**M54 to M6 Link Road**

**TR010054**

**8.8 P(D) Draft Statement of Common  
Ground with Hilton, Featherstone &  
Brinsford and Shareshill Parish  
Councils**

October 2020

Drawing file: TR010054 / TR010054-001020-TR010054 M54 6.3 Figure 2.7 Draft Masterplan Sheet 5 of 5.pdf

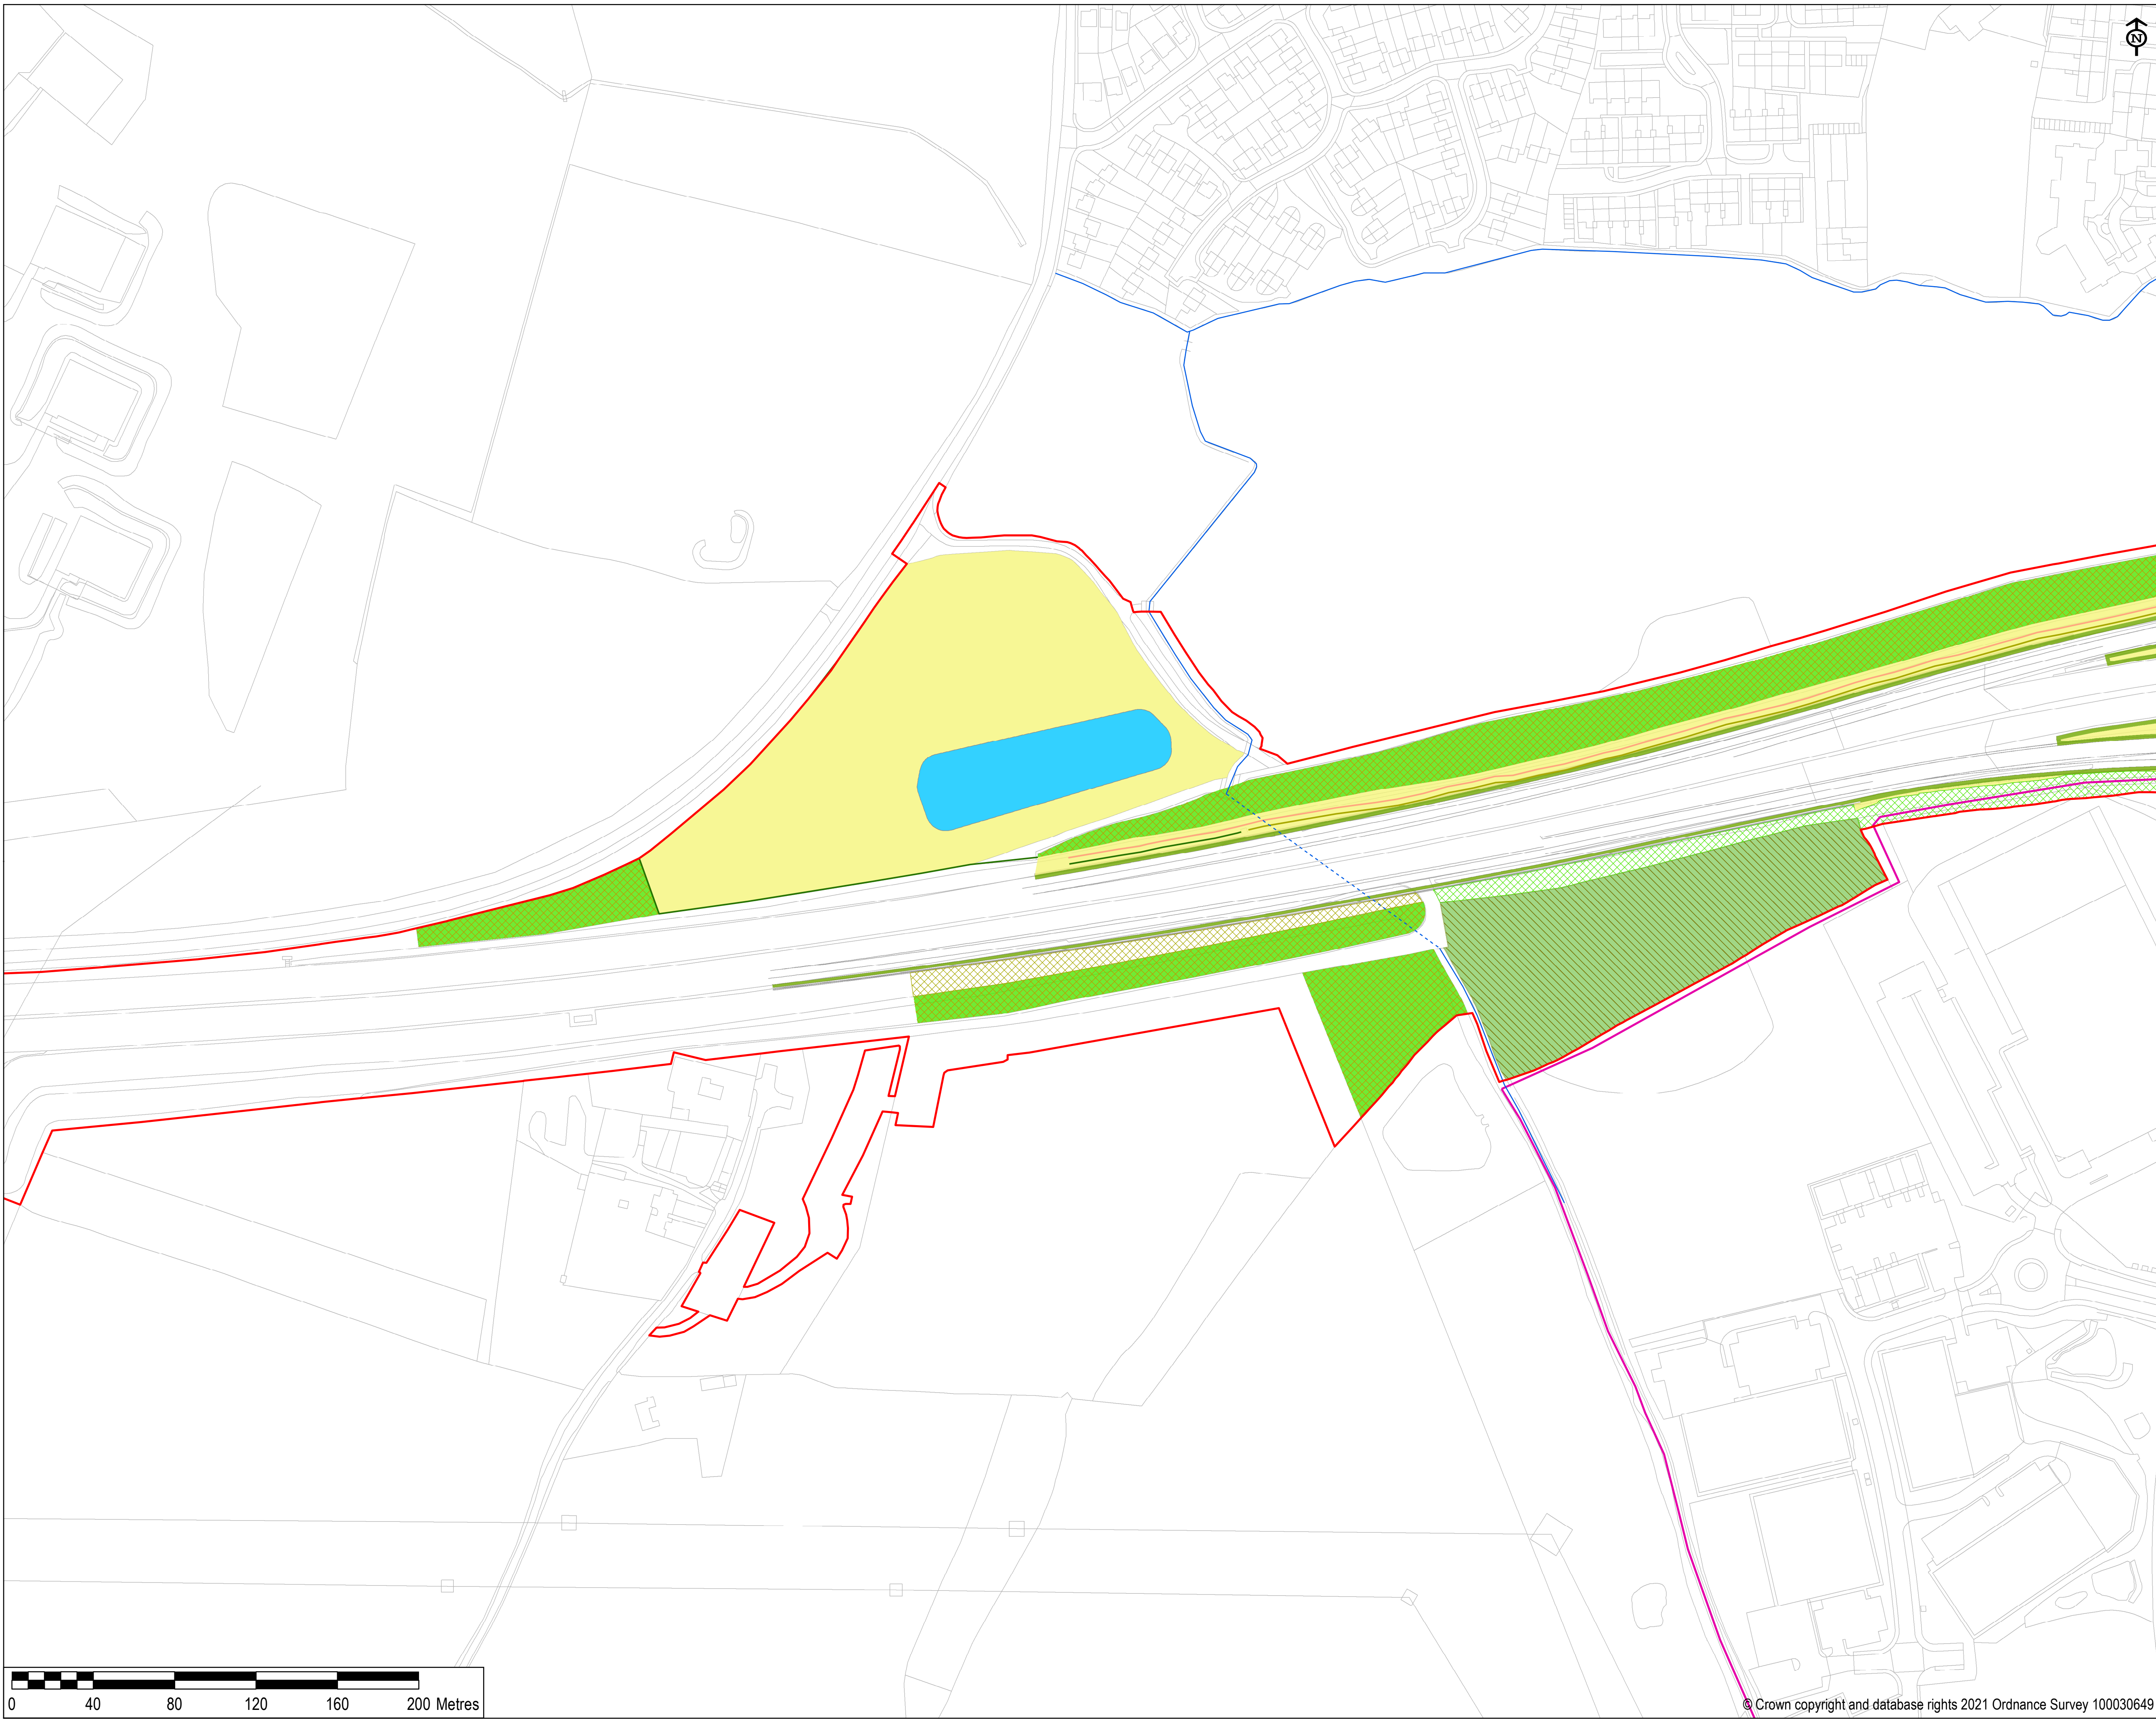
Environmental Mitigation	<p>From Hilton Parish Council questionnaire s42 Consultation Response:</p> <p><i>'The land opposite houses in Dark Lane must be compulsory purchased if this route goes ahead, also the land used for a car boot at moment, and both fields must</i></p>	<p>Mitigation measures are illustrated on the Environmental Masterplan (Figure 2.1 to 2.7 of the Environmental Statement [APP-057 to 063/6.2] and described in the OEMP, [APP-218/6.11]).</p> <p>The area of land required for environmental mitigation both south and north of Hilton has been reduced through the Scheme changes as a result</p>	Under discussion	Low

<p><i>be planted as woodland to mitigate natural environments that will be destroyed. The ecology pond on the car boot field must go ahead to mitigate losing part of Lower Pools. Planting this land as woodland would protect Hilton from further development and go some way to mitigate environmental damage.'</i></p>	<p>of ecology surveys completed this year, but a significant proportion of the field used for the car boot sale will still be required.</p> <p>The ecology pond on the car boot field is proposed as part of the Scheme. Highways England agrees the pond and woodland is necessary to mitigate for the loss of habitat at lower pool (ponds surrounded by woodland). A large proportion of the car boot field would be planted with woodland.</p>			
	<p>Request for trees to screen Shareshill from increased noise.</p>	<p>No significant operational traffic noise effects are anticipated in Shareshill village due to the operation of the Scheme. The change in traffic noise levels in Shareshill village due to the implementation of the Scheme is primarily due to two factors: a) the large reduction in traffic flows on the existing A460 at the south-east edge of the village, as traffic is re-routed onto the new link road, which is further away from Shareshill; and b) the small increase in traffic flows on the local roads (Church Road and School Lane) within the village due to re-routing of traffic in/out of the village once the junction with the A460 is relieved of the existing high traffic flows with the Scheme.</p> <p>The noise assessment is based on the impact at the worst affected facade of each residential property i.e. if one facade experiences an increase in traffic noise levels but all the other</p>	<p>Under Discussion</p>	<p>Medium</p>

<p>enable the resident to reverse from their property with no further space for people to park. The property would be accessible to refuse trucks stopping/turning in Park Road.</p> <p>The mitigation measures currently proposed are illustrated on the Environmental Masterplan (Figure 2.1 to 2.7 of the Environmental Statement in [APP-057 to 063/6.2] and described in the Outline Environmental Management Plan, [APP-218/6.11]), Ref D-L1 describes provision of a landscape design that includes areas of amenity grassland, grassland with bulbs, species rich grassland and native tree and hedgerow planting. Key elements of the landscape design include: areas of woodland to provide visual screening (particularly for residents of Featherstone, Dark Lane and Hilton Lane), landscape integration and ecological habitat; species rich grassland to provide landscape integration and ecological habitat; individual trees to echo the parkland character around Hilton Park.</p>
